**Kamay Ferry Wharf Project (SSI 10049) –
Environmental Assessment**

Detailed advice to DPIE Planning & Assessment regarding the Kamay Ferry Wharf Project (SSI 10049) – Environmental Assessment

1.0 Groundwater Take, Impacts and Management

Figure 17-6: ASS occurrence probability at Kurnell

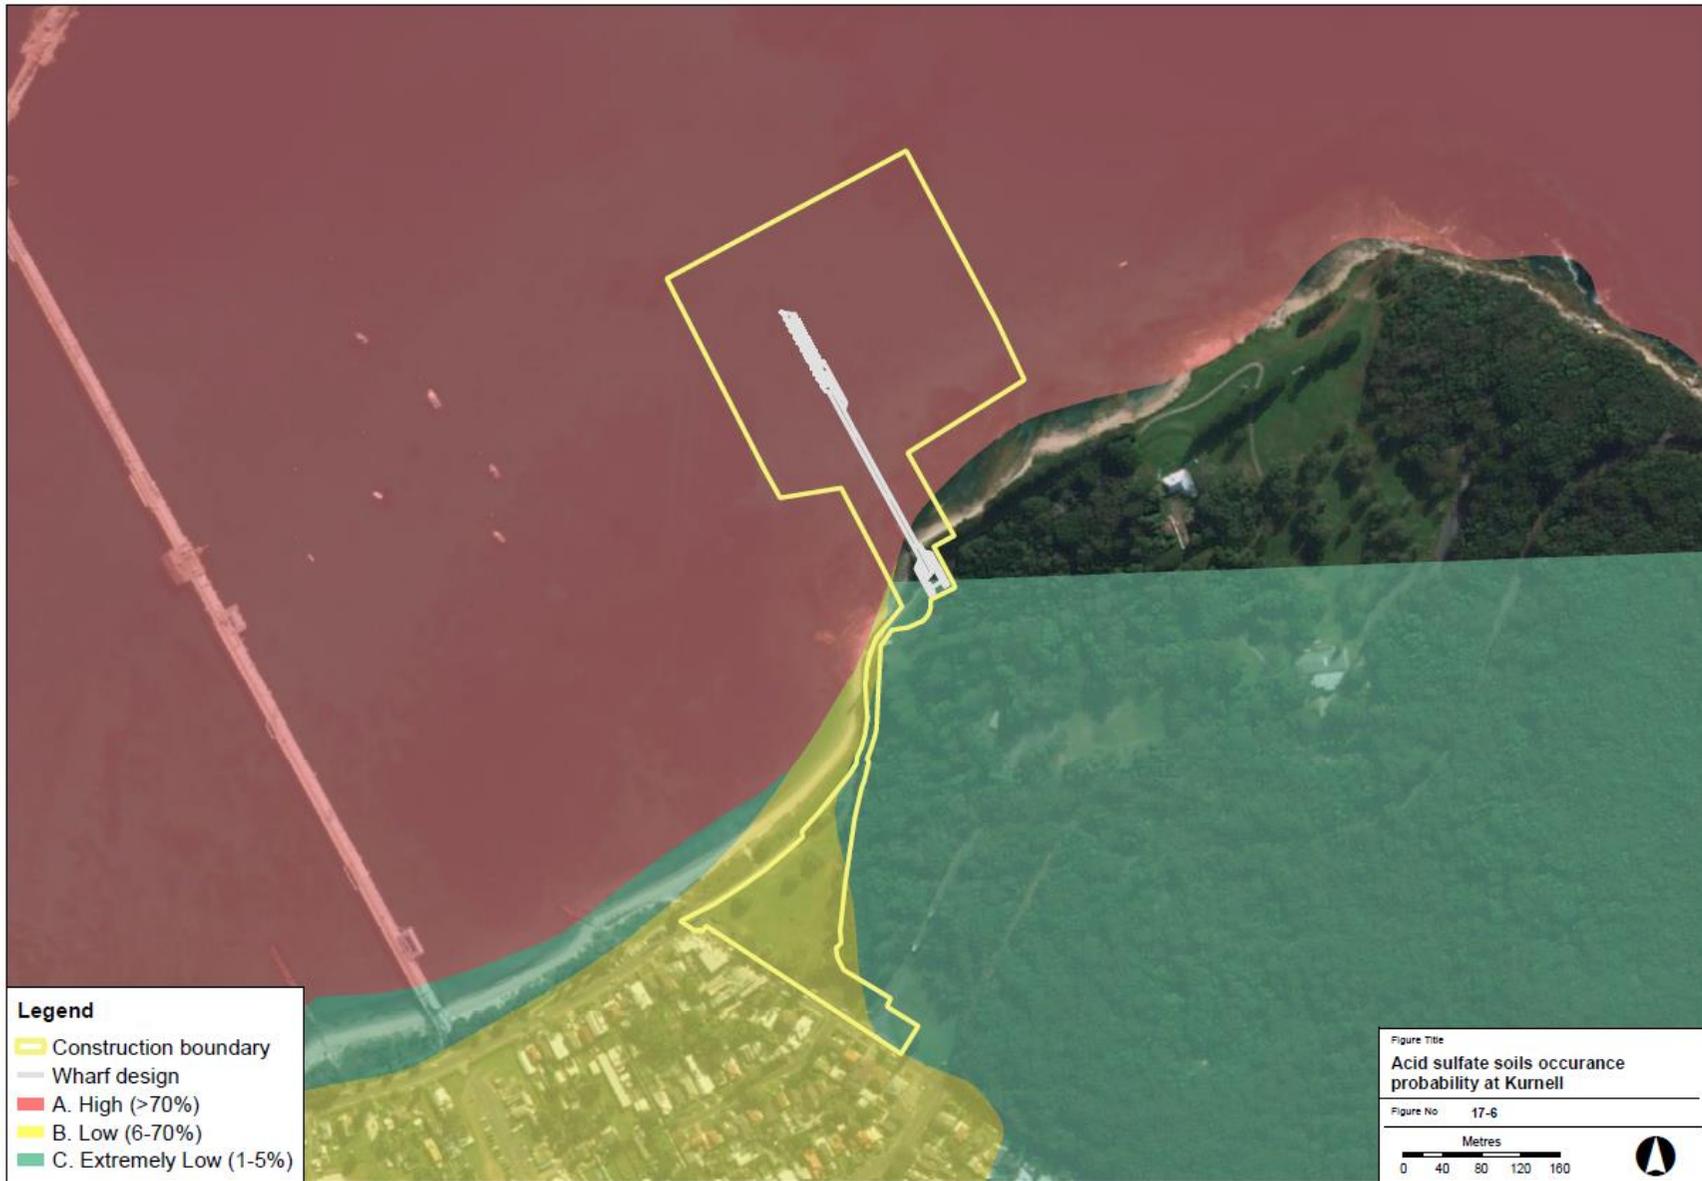
The pile structures for both the La Perouse and Kurnell wharves will extend through sand deposits that have a high probability of occurrence for ASS. Any disturbance of these sediments results in a risk of oxidising and mobilising these ASS and causing contamination of the nearby watercourses and aquifers. In addition, there is potential for organic contamination around the La Perouse project area by drilling into the Botany Sands aquifer. DPIE agrees that the groundwater contamination risk to be minor since the connection will be temporary and local during pile construction. However, soil and water quality monitoring is required to identify and manage any contamination if it does occur.

- a. As per recommendation 1b above, the Proponent must obtain a Water Access Licence (WAL) under the *Water Management Act 2000* prior to any water take, unless exemptions apply. A list of possible exemption that may apply are found in Schedule 4 of the Water Management (General) Regulation 2018.
- b. The Proponent should be required to implement a soil and water quality monitoring and Acid Sulfate Soils (ASS) management plan.
